Subject: RE: Attached letter from Kirklees Council regarding application number 2024/93621 at location 10, Arkenley Lane, Almondbury, Huddersfield, HD4 6SQ

Please arrange for the inclusion of the following condition for the above site:

Proposed Site Plan - 1:250

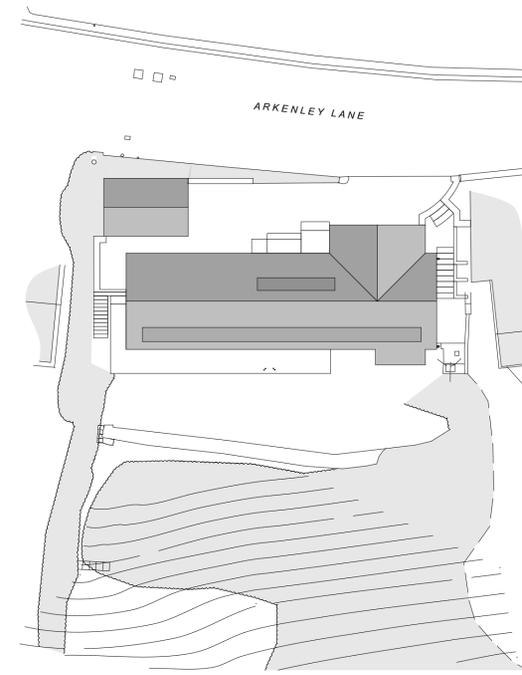
- 1) Before the development commences a scheme detailing the location and cross-sectional information together with the proposed design and construction details for the new building retaining wall adjacent to the existing private wall supporting Arkenley Lane shall be submitted (via submission of an AIP) and approved by the Highway Authority in writing. The approved scheme shall be implemented prior to the commencement of the proposed development and thereafter retained during the life of the development.
